From: Andrew Wood
Sent: 10 July 2017 16:29
To: 'Ed Miller'
Cc: Planning.Responses
Subject: RE: FG/198/16 - Plans

From: Ed Miller [REDACTED]
Sent: 03 July 2017 16:04
To: Andrew Wood
Cc: sally henderson; Craig Savage; Roger Elkins; Carole Robertson
Subject: FG/198/16 - Plans

Mr Wood: Neither the latest Ground floor Plans nor the Street Scene, Sea Drive, both recently submitted, show any parking places fronting onto Sea Drive. But the covering minute from the architects, covering the revised plans (posted 29 June) refers to 12 parking places in all. The plan for the underground car park shows spaces numbered 3 to 12: are spaces 1 and 2 still intended to be on the ground floor, fronting Sea Drive? If so, why are they not shown on the latest plan and street scene? Isn't the absence of these prominent features very misleading for Members of the Development Control Committee when they come to consider the application. Or is there something I have misunderstood?- Ed Miller (Secretary, Ferring Conservation group)

STREET SCENE SEA DRIVE

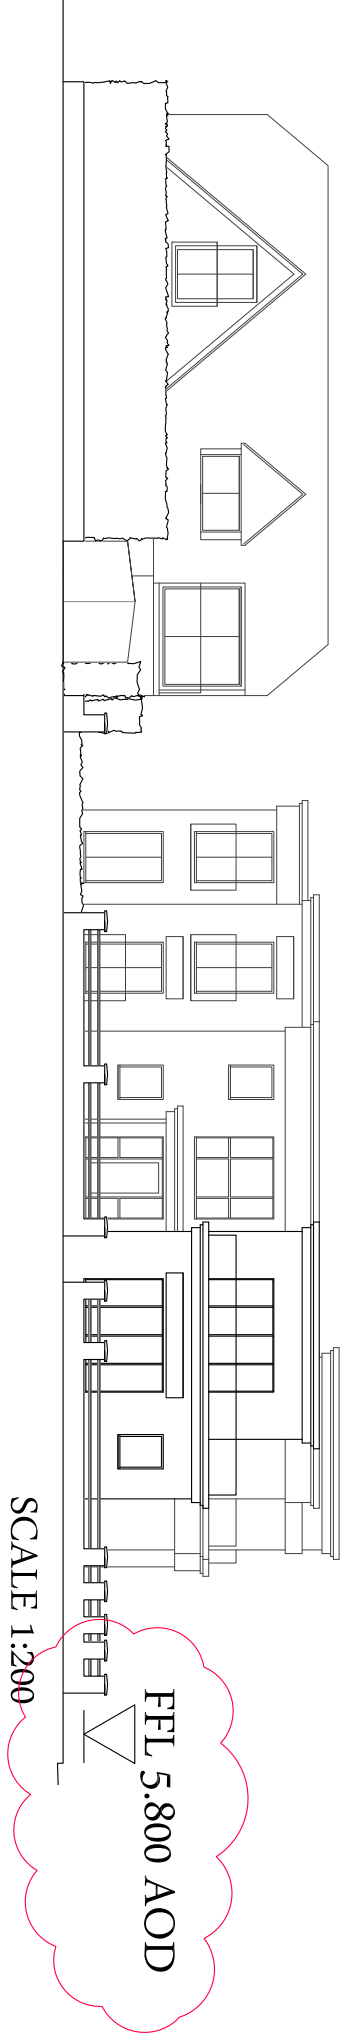
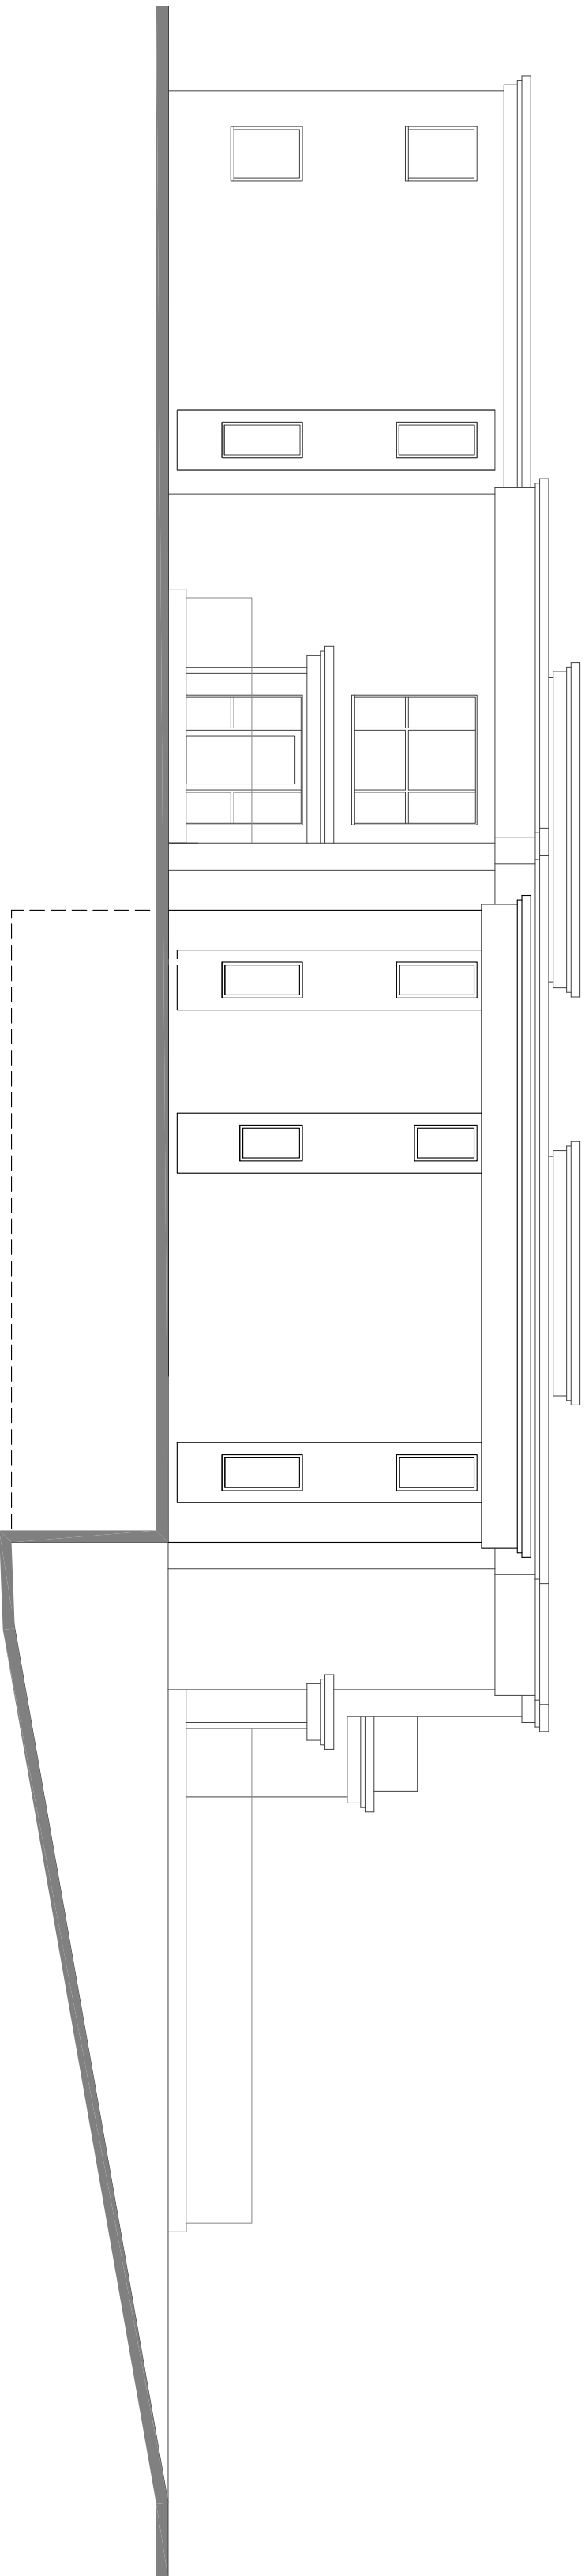
Mr Wood: Thank you. I can see the drawing you refer to (dated 11 April, isn't it?). In what sense is it 'approved'? I would still suggest that the latest Ground floor plan, and the Street Scene in Sea Drive, are misleading in that they do not show either the ground floor parking places (in the real street scene they would have cars parked on them) or the entrance to the underground car park. – Ed Miller

Yes they are still included and can be seen on Proposed Block Plan Dwg.no. 046/PL003 REV F Dated Apr 17 which is one of the approved plans.
